From: Richard Temple
Sent: 14 February 2018 15:23
To: Karen Parsons
Subject: FW: Ref Planning Application FP/268/17/PL update

From: Roger Spencer
Sent: 12 February 2018 11:35
To: Richard Temple
Subject: FW: Ref Planning Application FP/268/17/PL

Subject: Ref Planning Application FP/268/17/PL

PROJECT Gull Point Suites - On the Beach
TITLE Typical Sections
SCALE 1 : 100
DATE 20/09/17
DRG NO IBA/480/09
REVISIONS

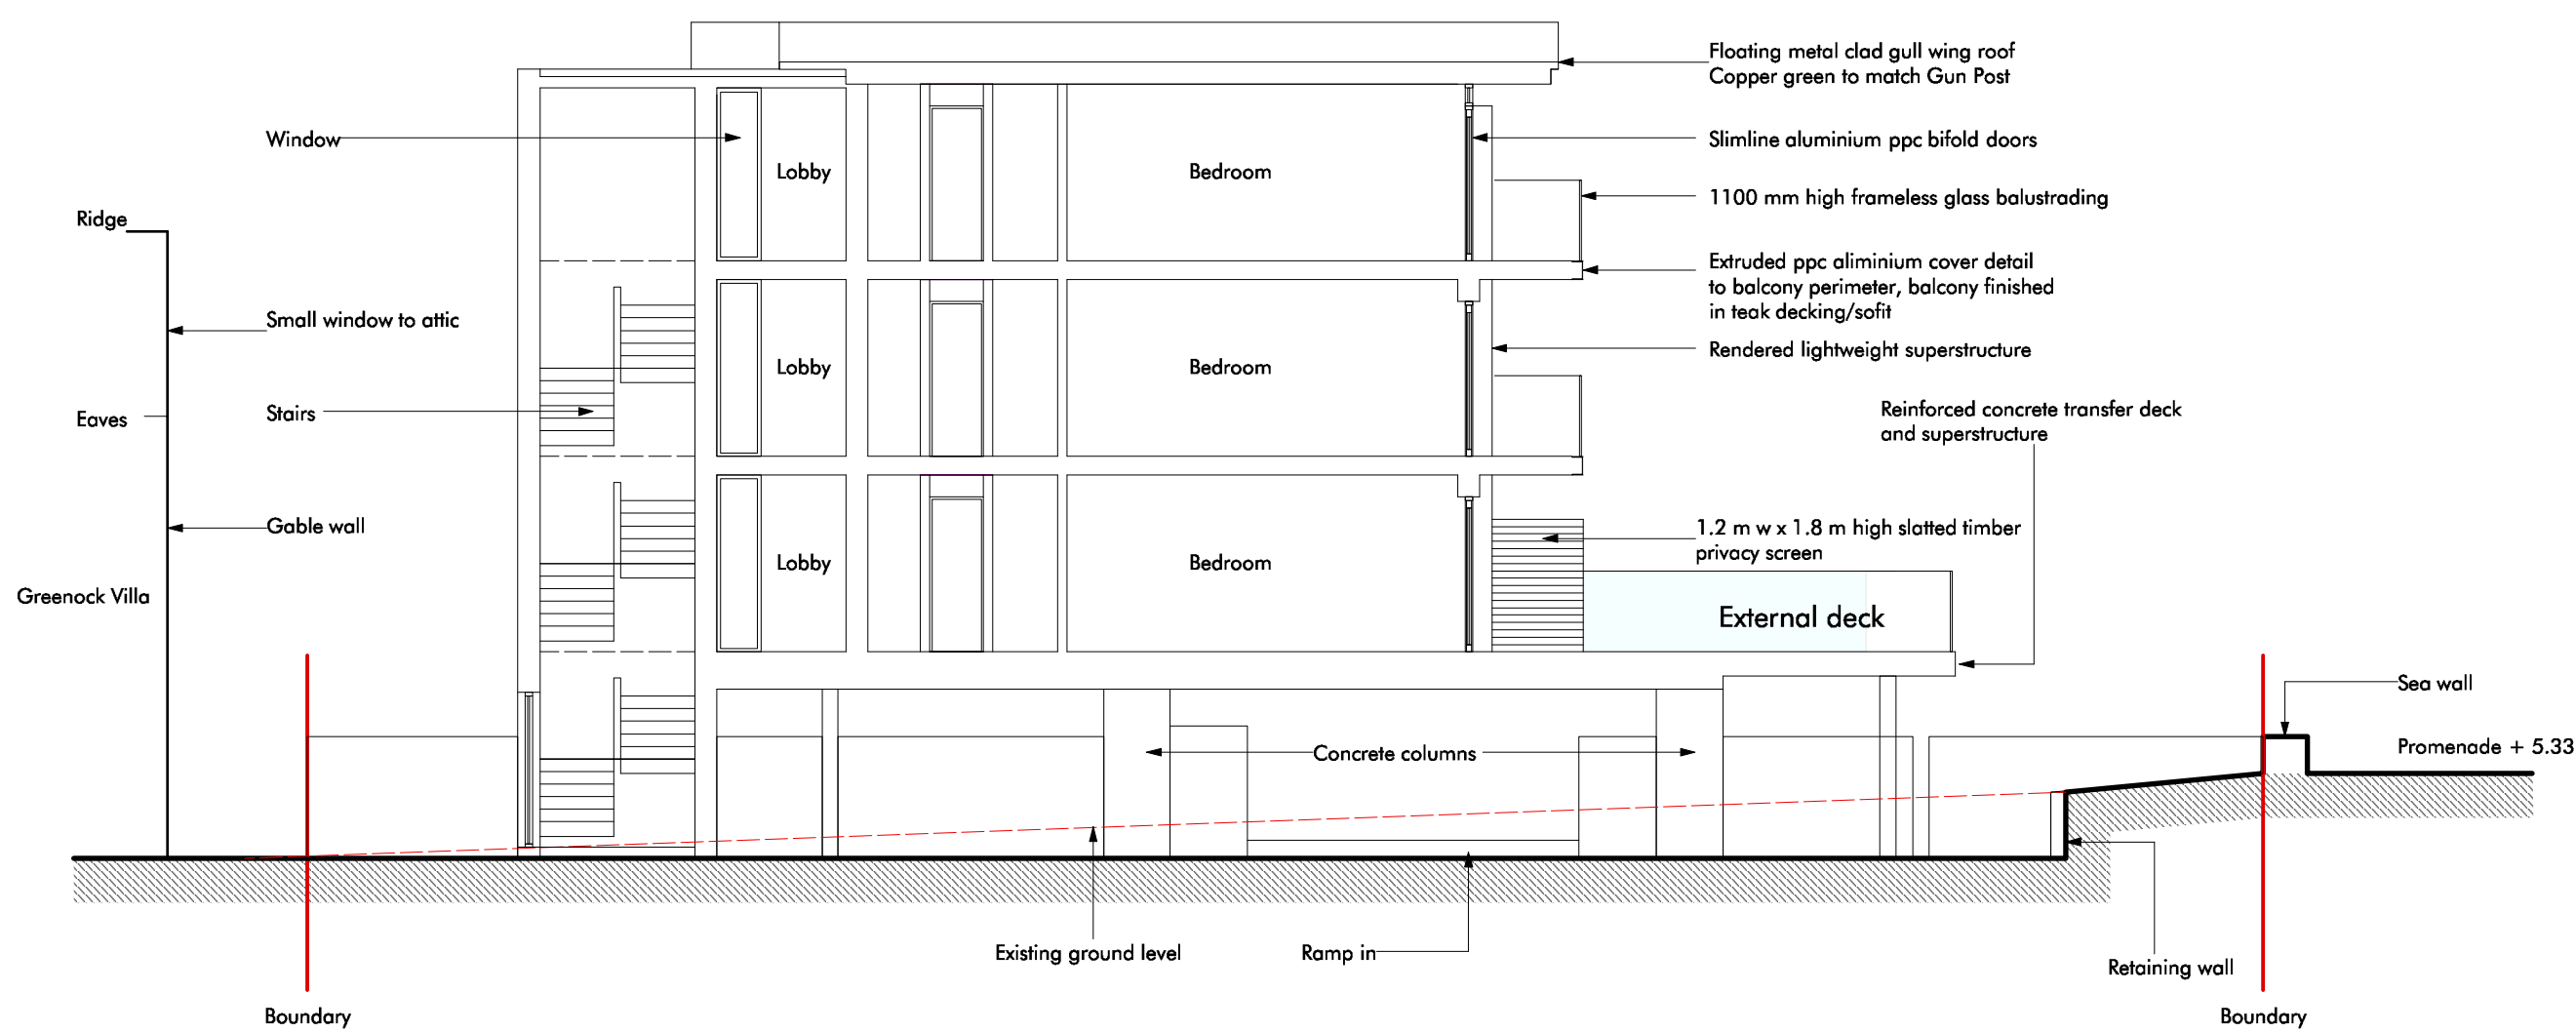
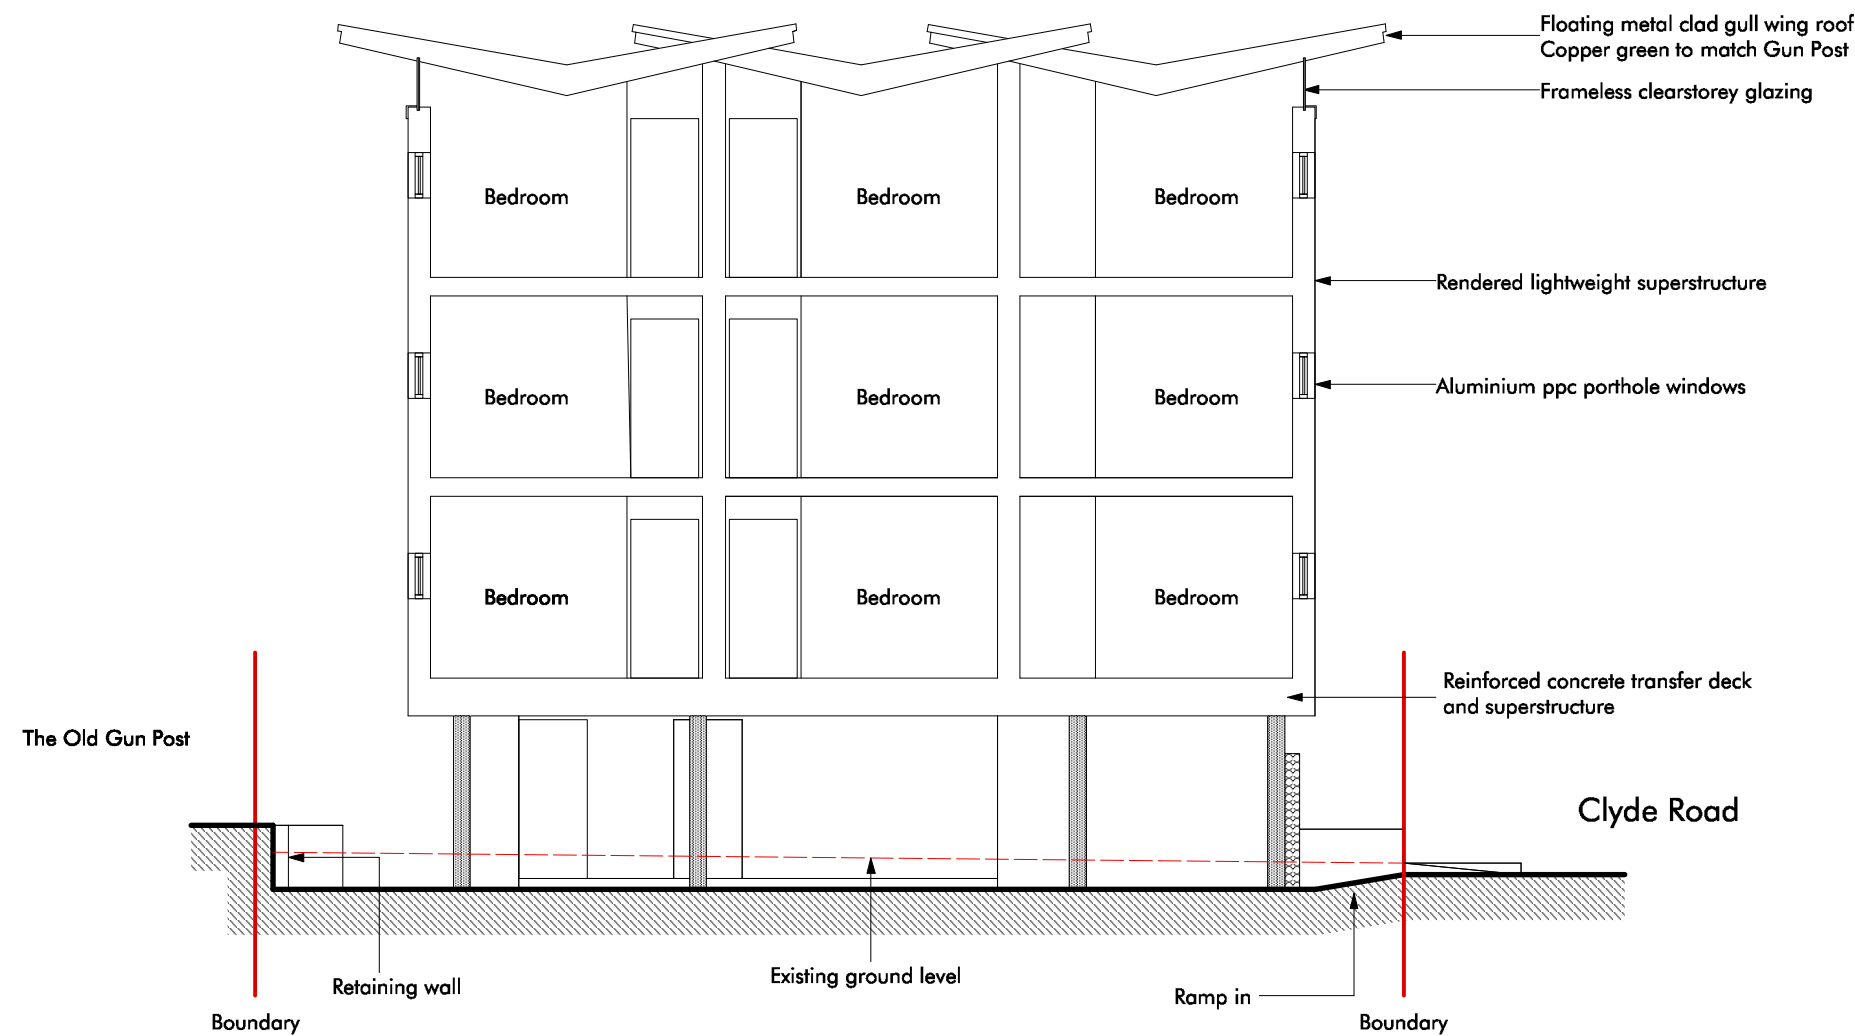
I will leave it to Richard Temple to decide whether or not the main set of drawings (inc. the section through the site) needs to be revised to reflect this detail.

Whilst these references allude to the proposed low timber wall, they do not give sufficient importance, in my opinion, to the job of keeping the sea out. I would have expected to have seen the wall shown in both of your Elevations drawings as well as the Sections drawing (unless that is it is concealed by the red boundary line!).

We are not of the opinion that we need to amend the main drawings to reflect the additional wall detail as we can include it as a separate drawing, nor are we of the opinion that we need to re-advertise the application owing to the new drawing.
